# memorandum

date May 15, 2017

subject Proposed 8316 Avalon Drive Residence Critical Areas Determination (CAO17-002) –  
Environmental Review

STREAM BUFFER MITIGATION PLAN
EXISTING CONDITIONS
PLATOU RESIDENCE
8316 AVALON DR.
MERCER ISLAND, WA 98040

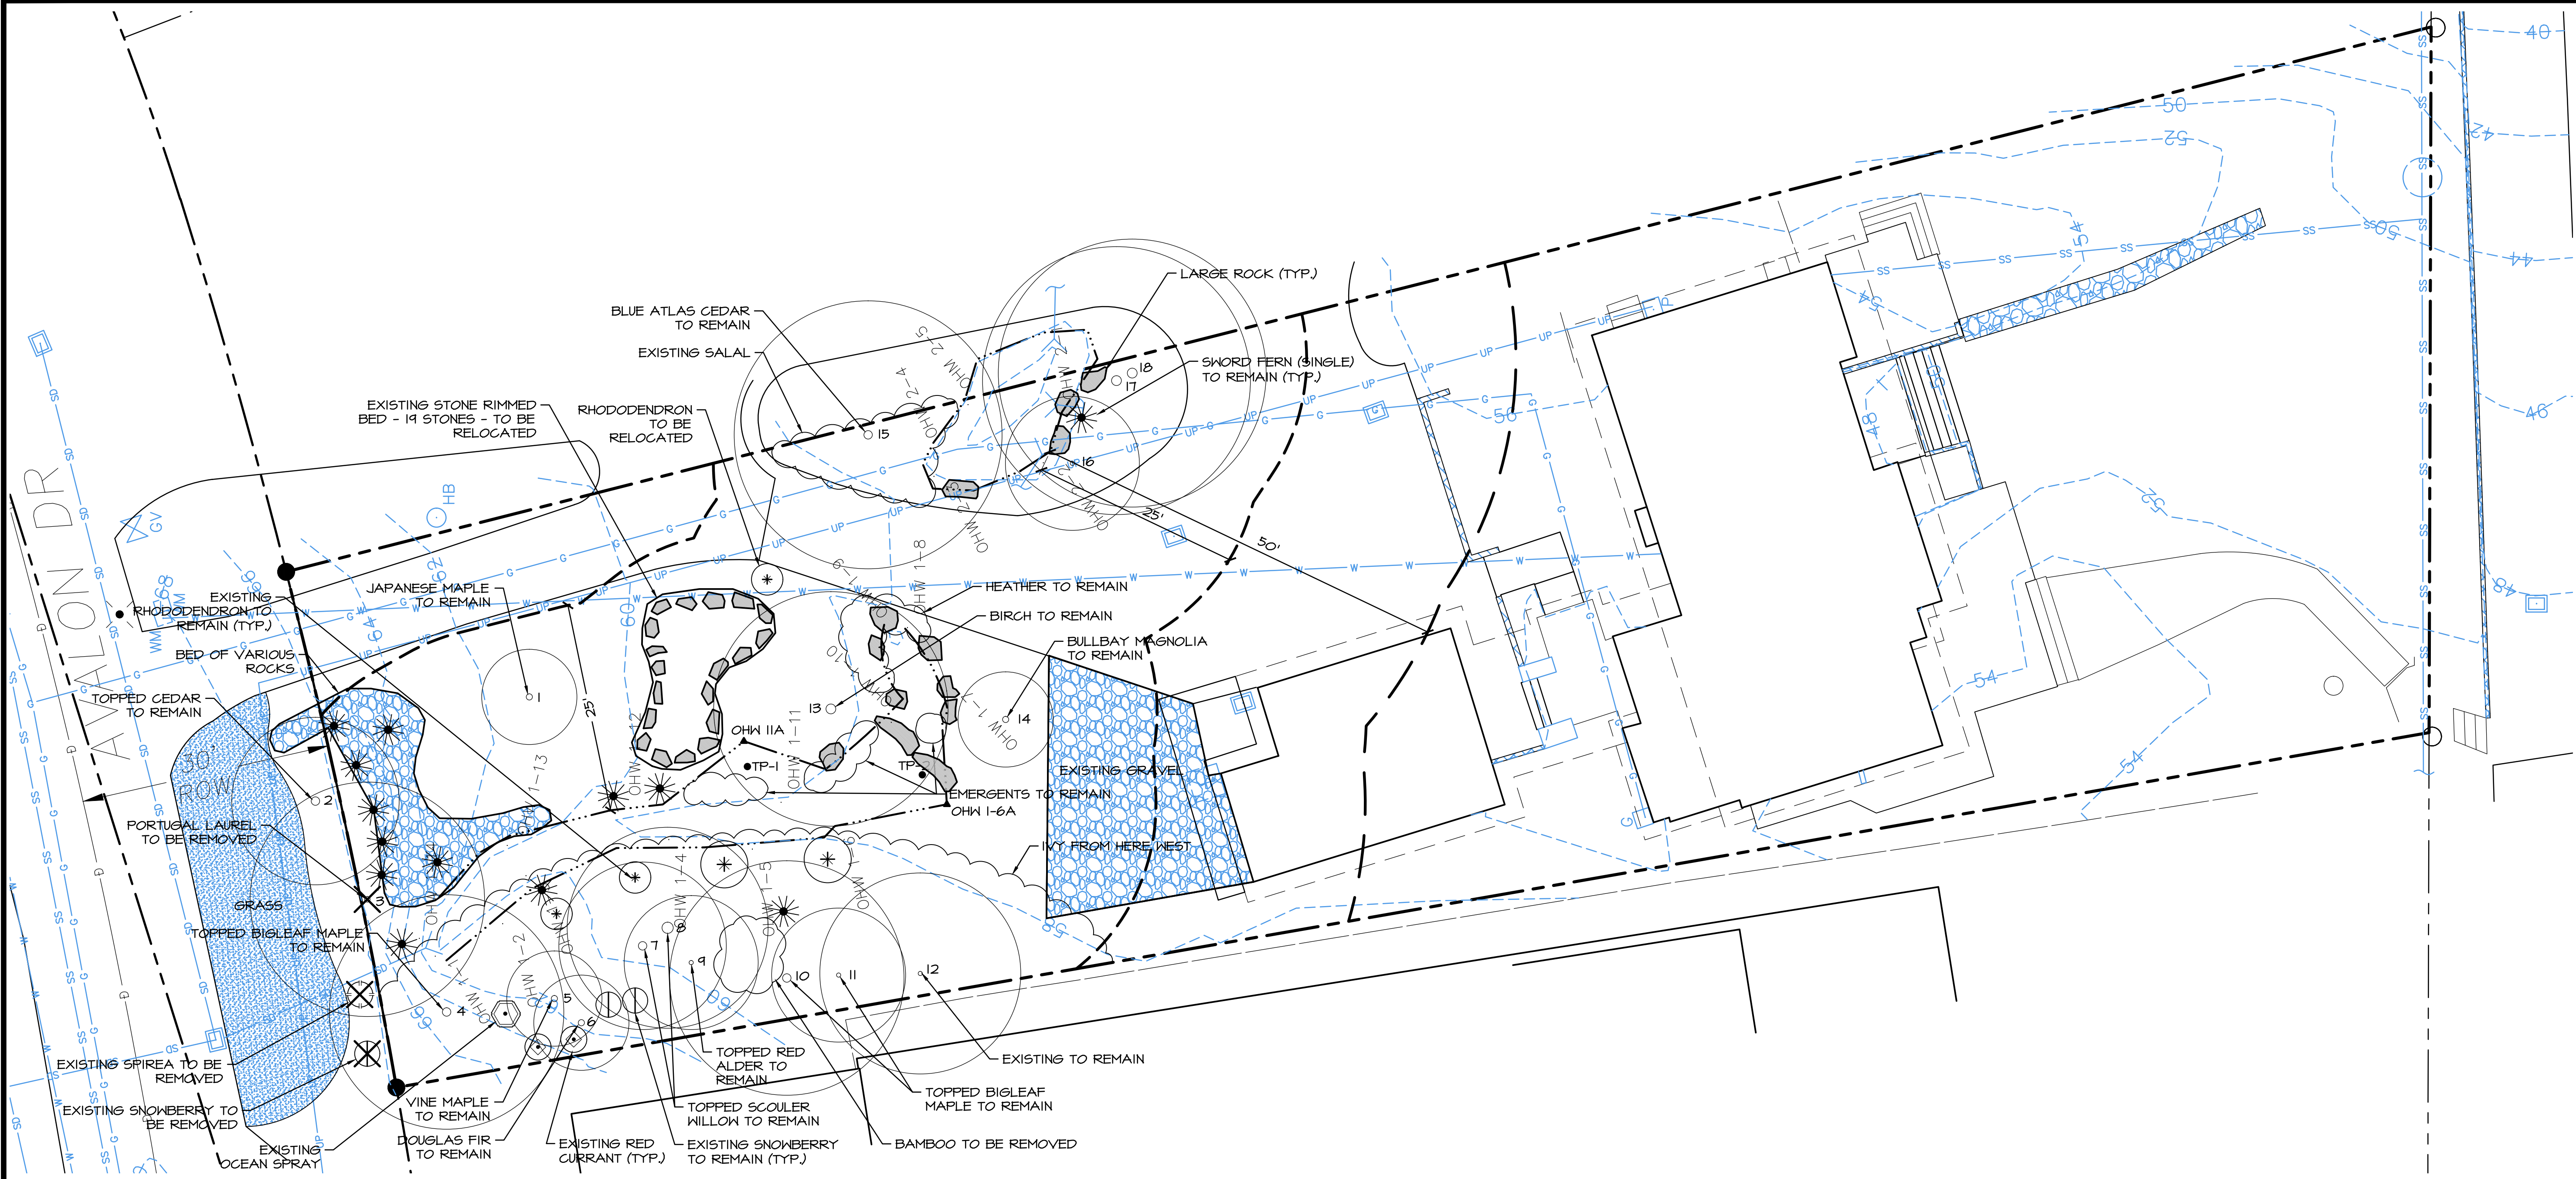
- Based on our observations of site conditions, we recommend that two relatively small areas adjacent to the on-site stream be further investigated for wetland indicators, with documentation provided in an updated CAS. Based on this investigation, if any wetland area is identified or the stream OHWM is expanded, we recommend that project materials be updated to reflect conditions and associated MICC Chapter 19.07 requirements.

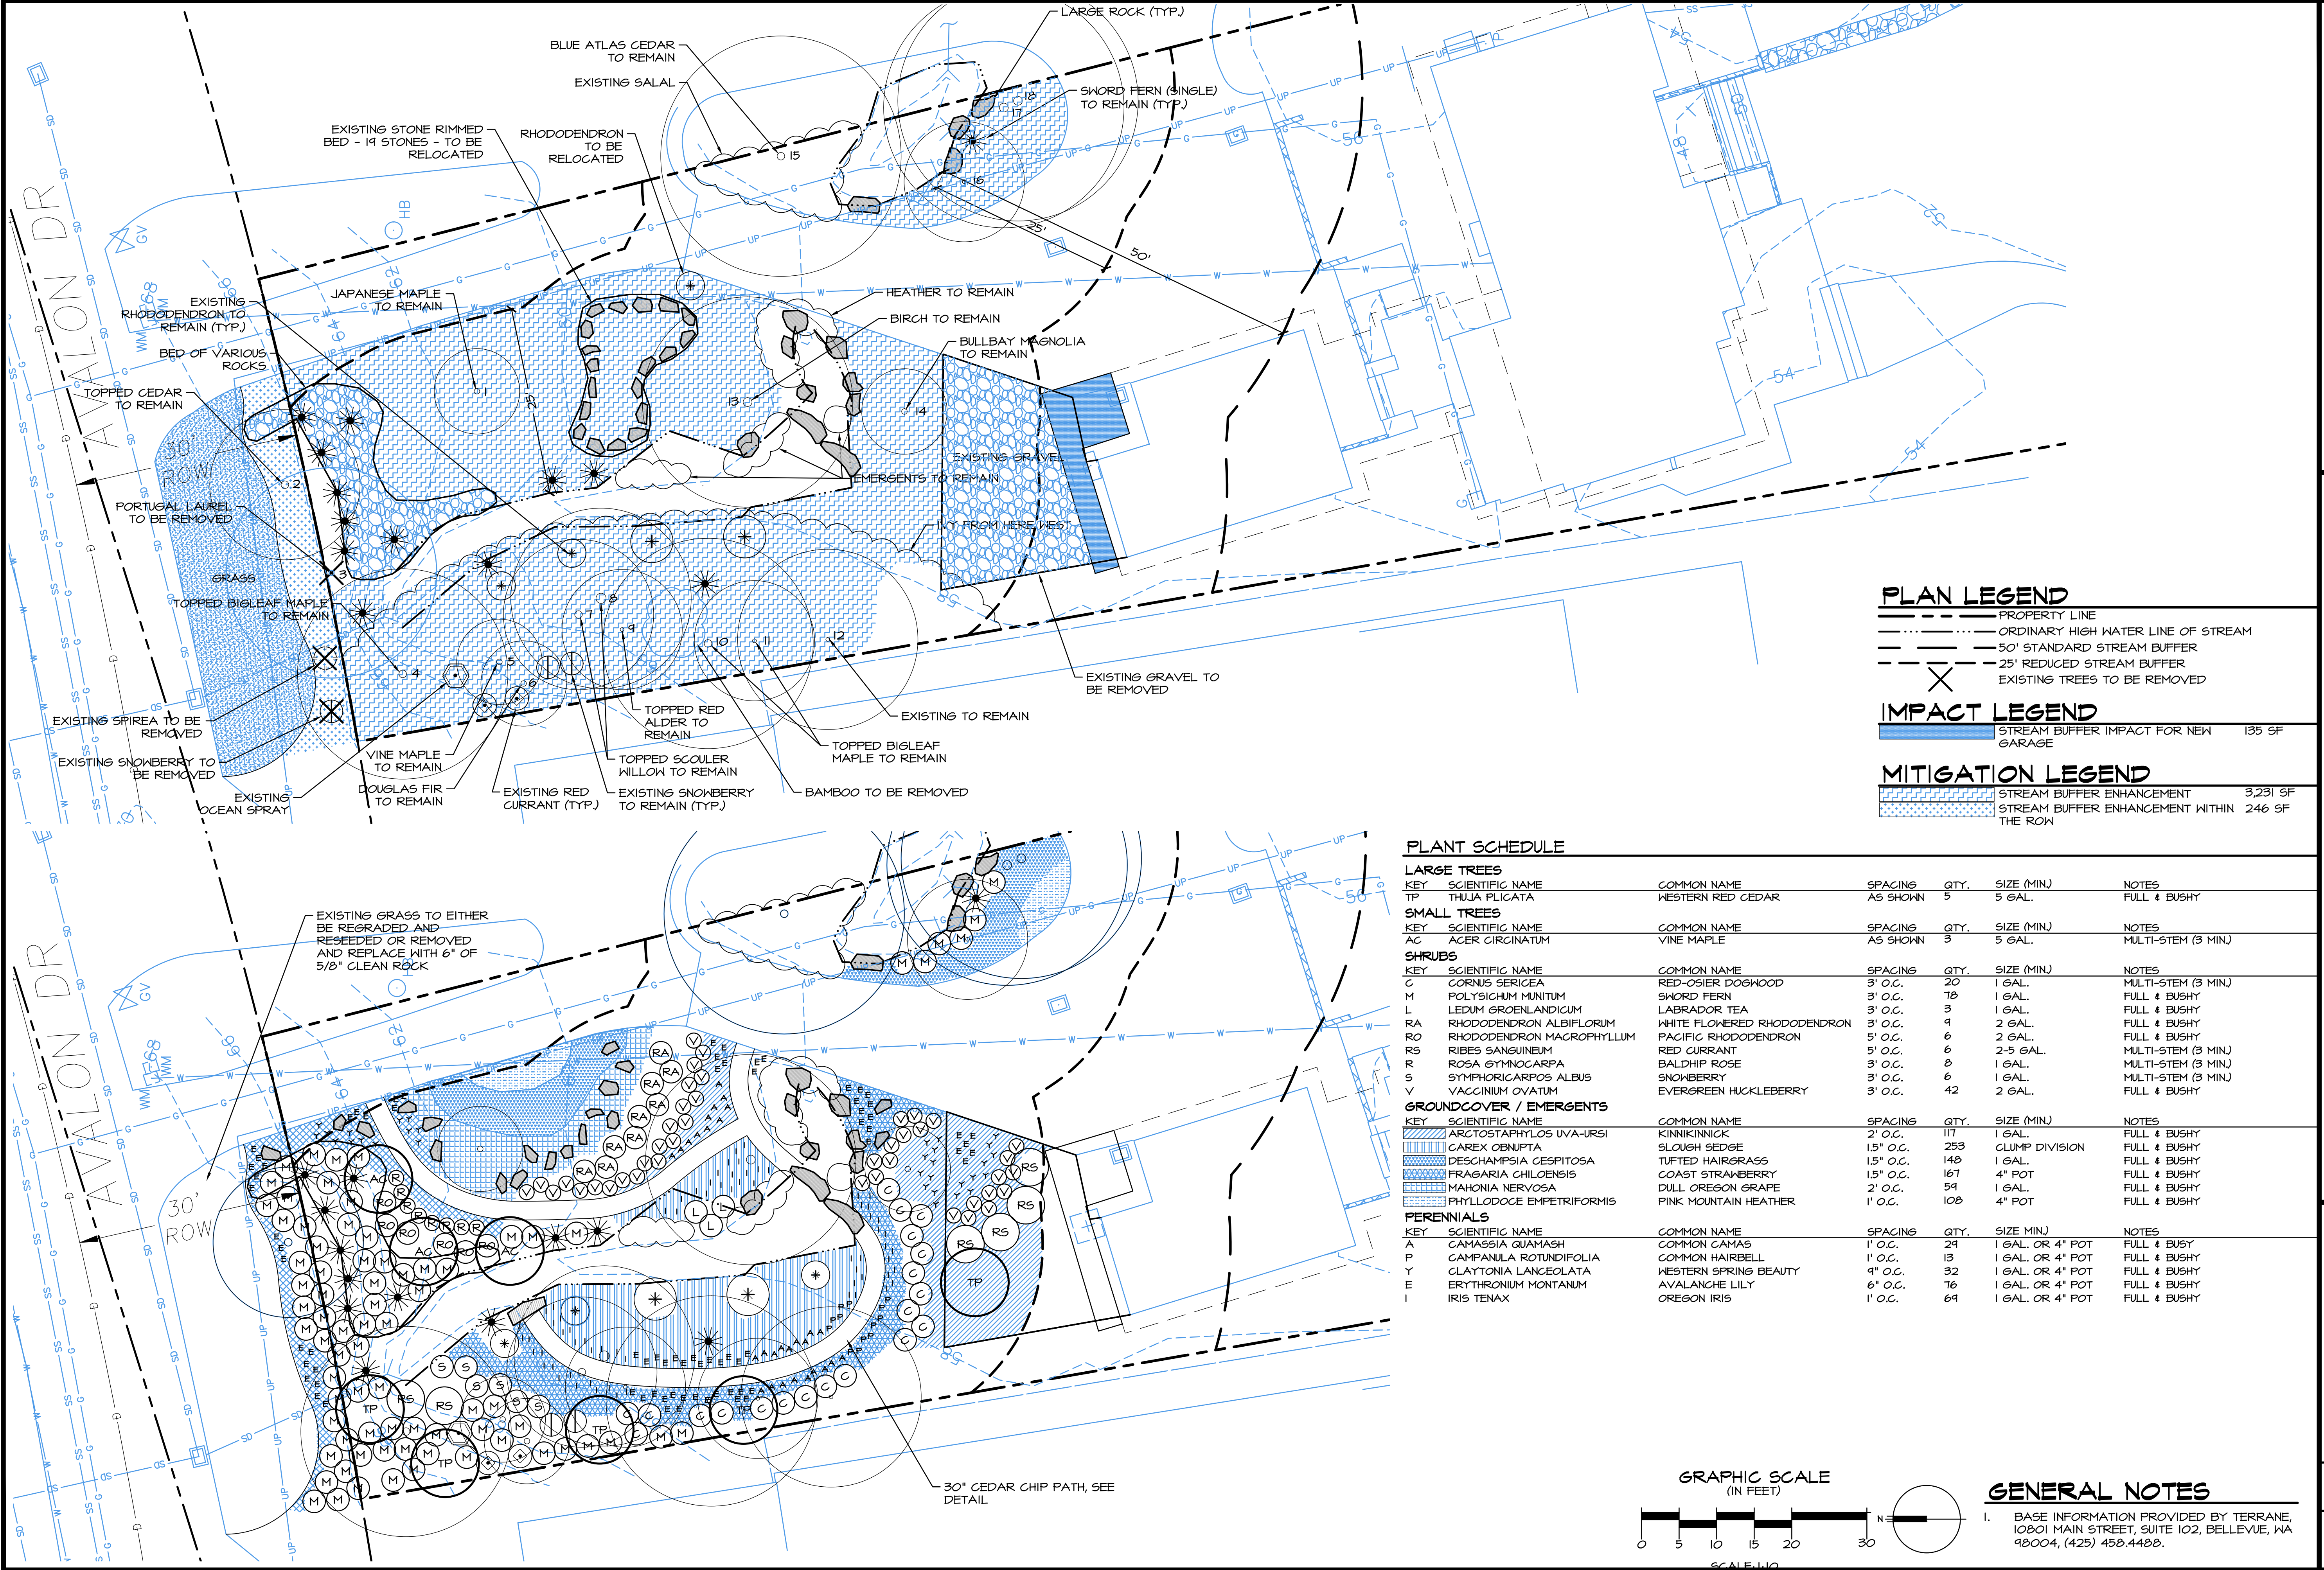
- In addition to proposed invasive species removal and buffer enhancement within the reduced buffer area, we recommend that the City require removal of the gravel parking area that would be within the 25-foot reduced buffer. This area should be incorporated into the buffer mitigation plan, including restoration of underlying soils and planting with native species. Removing the impervious surface within the 25-foot buffer combined with removing invasive species and replanting with native species is appropriate mitigation for the proposed buffer reduction.

- Update the planting plan to include Sections 3.0 through 6.0 from the CAS.
  - We recommend increasing the spacing of the western red cedars (*Thuja plicata*) to at least 15 feet apart to give them room to grow.

- On the planting plan, sword fern (*Polystichum munitum*) does not have a corresponding letter in the plant schedule. Confirm if “M” corresponds to sword fern and revise the plant schedule accordingly.

selected for these areas. For the areas noted on Figure 1, we recommend the following plant changes to species more appropriate for wet conditions:

- Substitute sword fern with Labrador tea (*Ledum groenlandicum*)
  - Substitute coast strawberry (*Fragaria chiloensis*) with bunchberry (*Cornus canadensis*)
  - Substitute common camas (*Camassia quamash*) with western columbine (*Aquilegia formosa*)
- The Construction Specifications should specify that pesticides are not permitted within the enhancement area.
